Application No: LU/141/25/PL
Site Address: 57 River Road Littlehampton BN17 5DD
Description of works: Partial demolition of number 57 River Road, change of use & re-development to provide a flatted development comprising 9 No. apartments with private amenity space, parking & cycle storage, including the partial demolition of the adjacent boundary wall to provide a new pedestrian access & the creation of a floating pontoon with resident morning spaces (resubmission following LU/251/21/PL). This application affects the character & appearance of the Littlehampton River Road Conservation Area & is in CIL Zone 4 (Zero Rated) as flats.

Thank you for your internet representation made on 31st August 2025 which has been recorded as an objection with the comments as follows:

Figure 3.9 Proposals - Second Floor

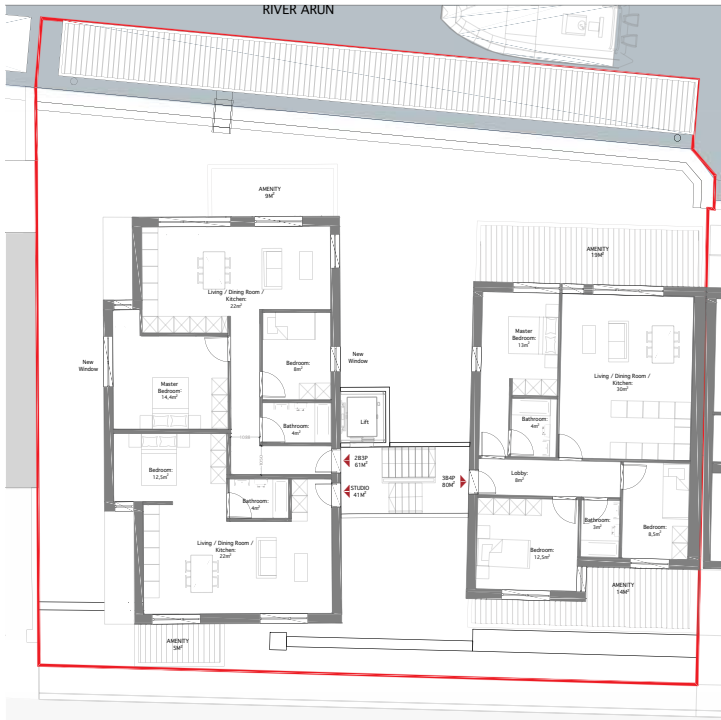
1. The second floor plan now has a window on the south east elevation which looks directly through the velux window of 49.
It shows partially obscure glass, however this would make no difference as its not full height.
Im unsure if there is a balcony on this level, however there is one above which also overlooks the velux window.
There is a boiler outlet and woodstove chimney from 49, very close to this elevation, which would cause complaints in the future. If this balcony was used.
There are also 2 levels of balconys on the north east elevation that will overlook and invade privacy from the entrance door and windows on the ground floor of 49.
Surely a balcony overlooking the river is sufficient.
The boundary wall of 49 is very thick flint with no damp course, so
I would suggest the concrete slab of the new car park has a suitable drainage gap between, and a barrier to
